RE: s96(1a) Boomerang Tower, Sydney Olympic Park Site 9

Below is a summary of changes for the proposed s96(1a):

Site 9, 3 Olympic Boulevard, Sydney Olympic Park

Proximity to Rail Corridor Site Plan +
Building Envelope

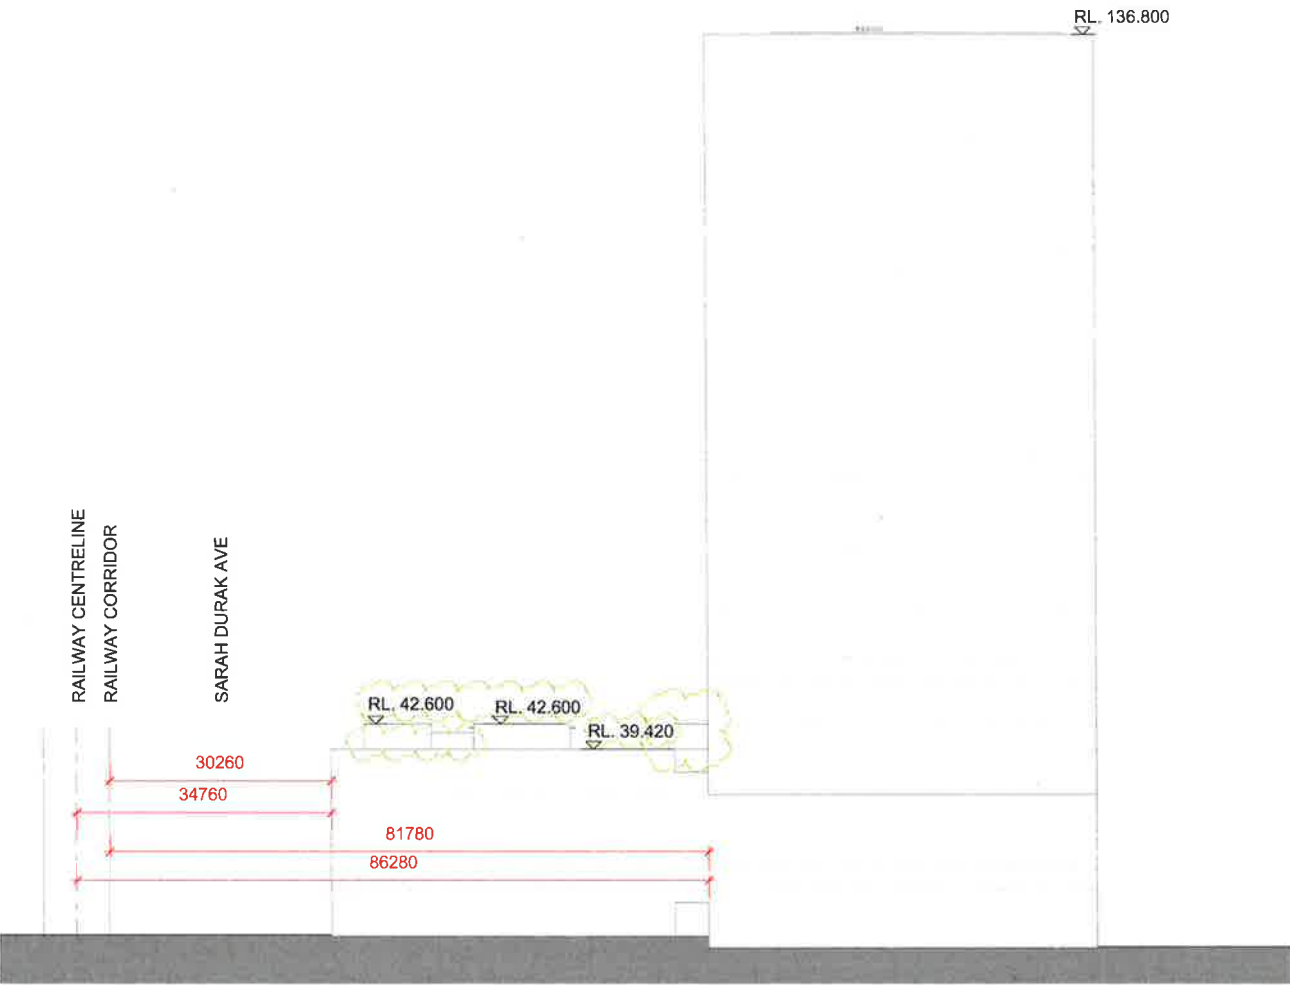
Proximity to Rail Corridor Site Plan + Building Envelope

Pavilion, Atrium, and Parapet heights reduced to match Approved Elevation Heights

General Arrangement Plan
Ground

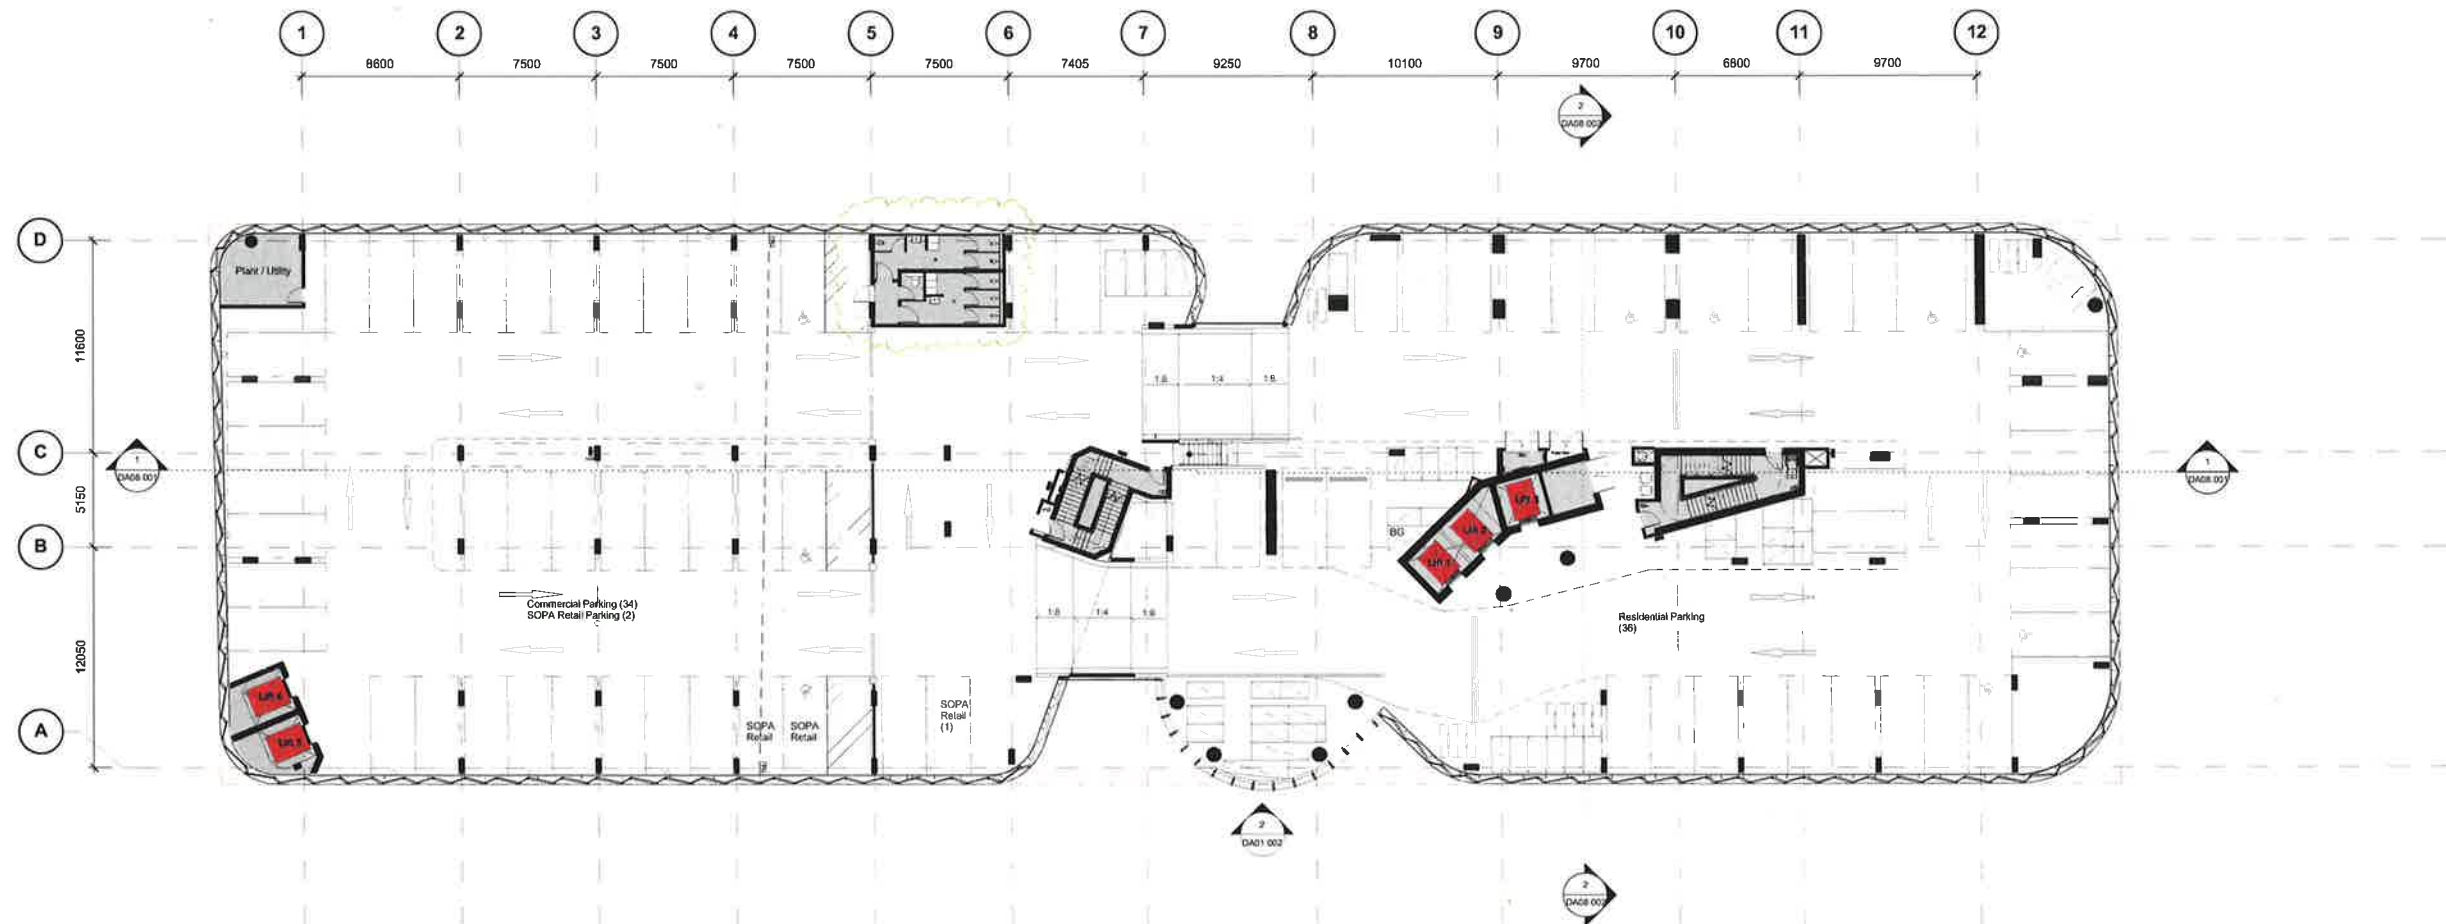
Ground Floor

Modifications to plant areas
Minor adjustments to wall locations
Removal of Sub-Station Kiosks with enclosure of façade to match streetscape elevation
Indicative locations of the non-loading bearing intertenancy walls, subject to confirmation
The proposed finish/material of the ground floor east façade is indicative however is it expected to be a combination of glass (finish/material 3) and metal cladding/louvres (finish/material 10).

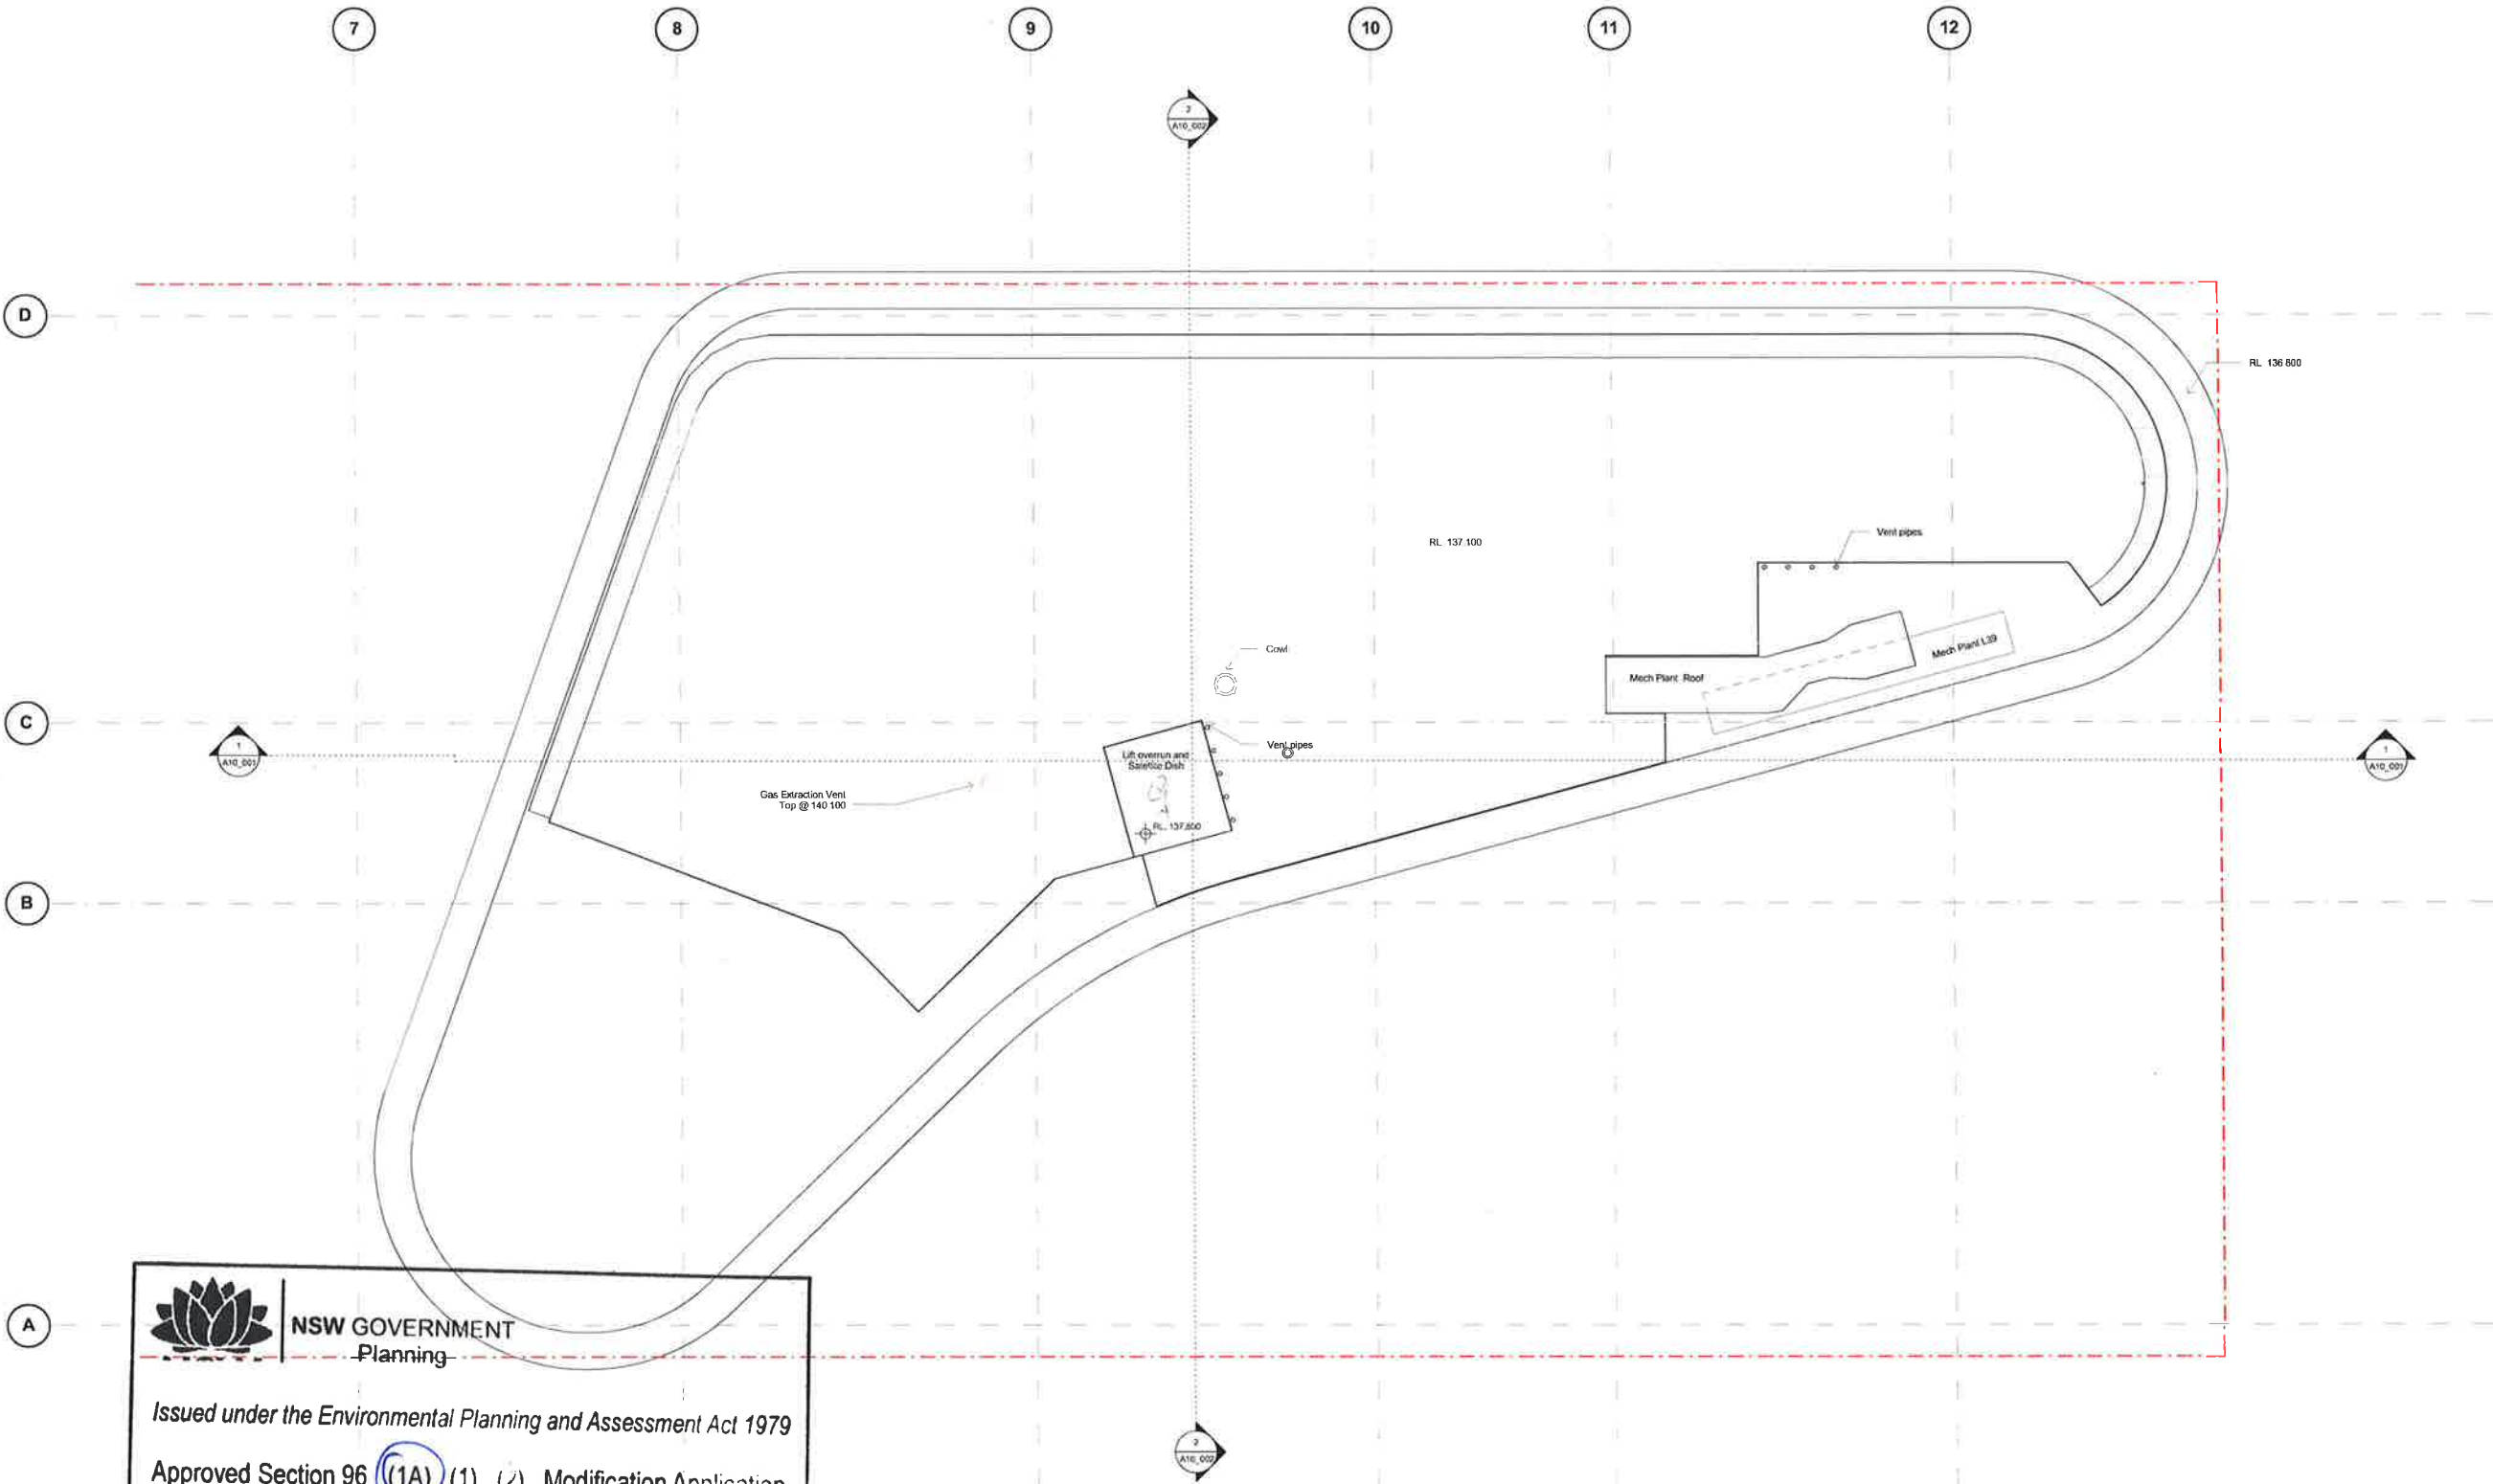
Level 9

East pavilion becomes a planter concealing services in void below landscape deck
Plant added to back of stair

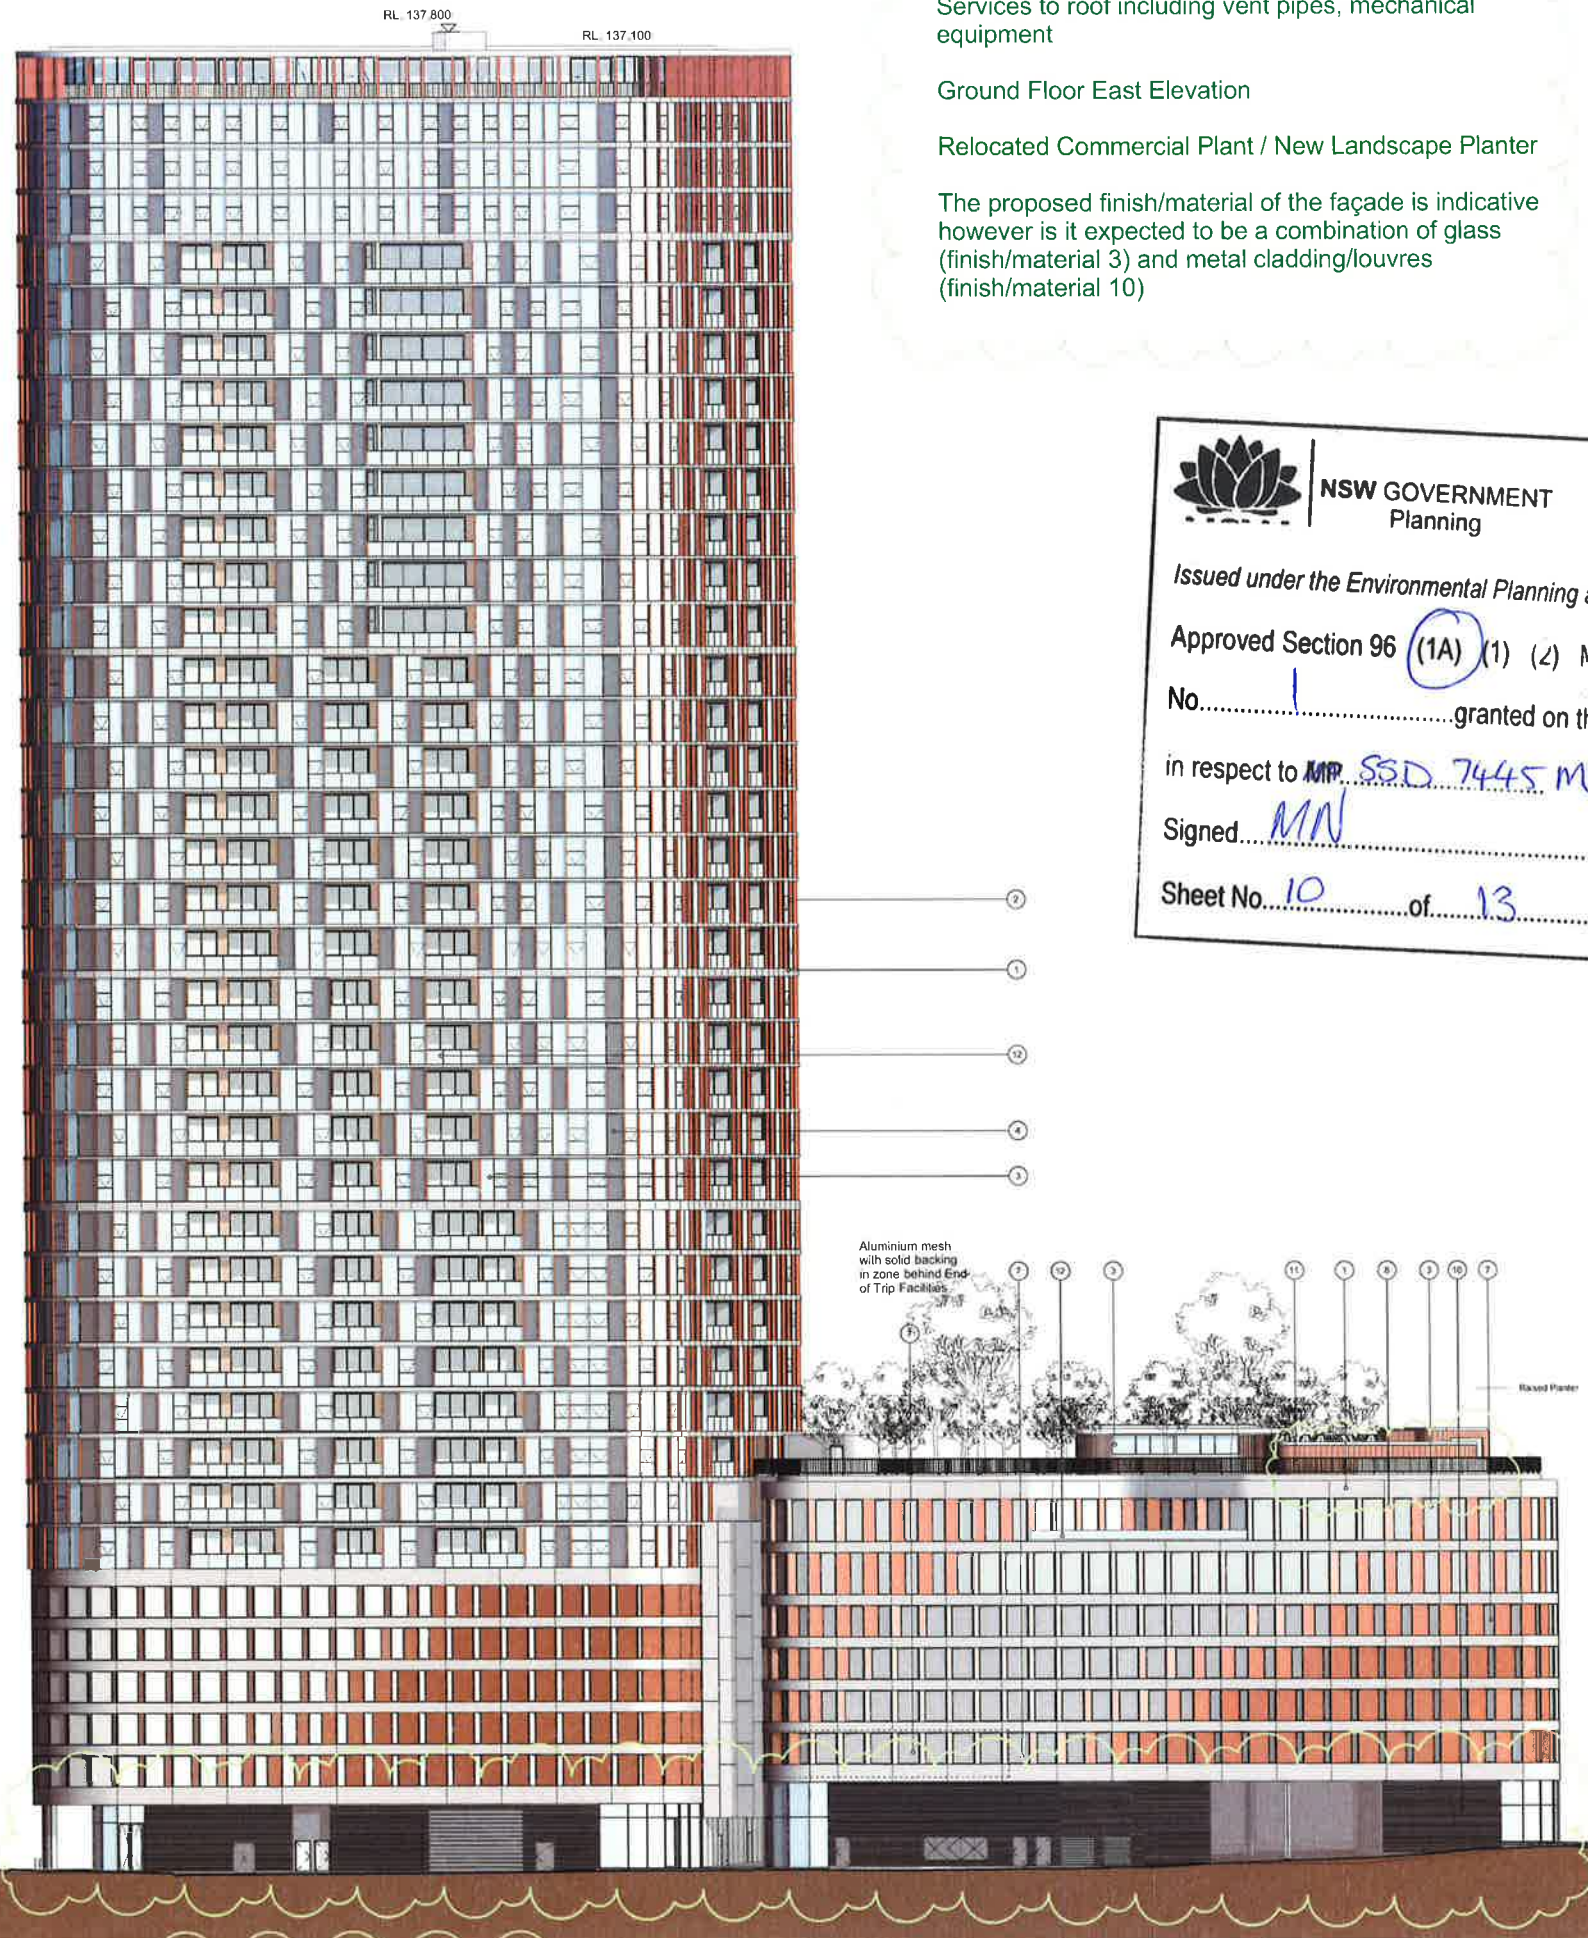
Roof

Services to roof including (vent pipes, mechanical equipment)
Roof extension

Ground Floor East elevation
Updated AC room façade treatment Level 7 - 37
Commercial Plant / New Landscape Planter
Services shown to roof (vent pipes, mechanical equipment)
The proposed finish/material of the ground floor east façade is indicative however is it expected to be a combination of glass (finish/material 3) and metal cladding/louvres (finish/material 10).
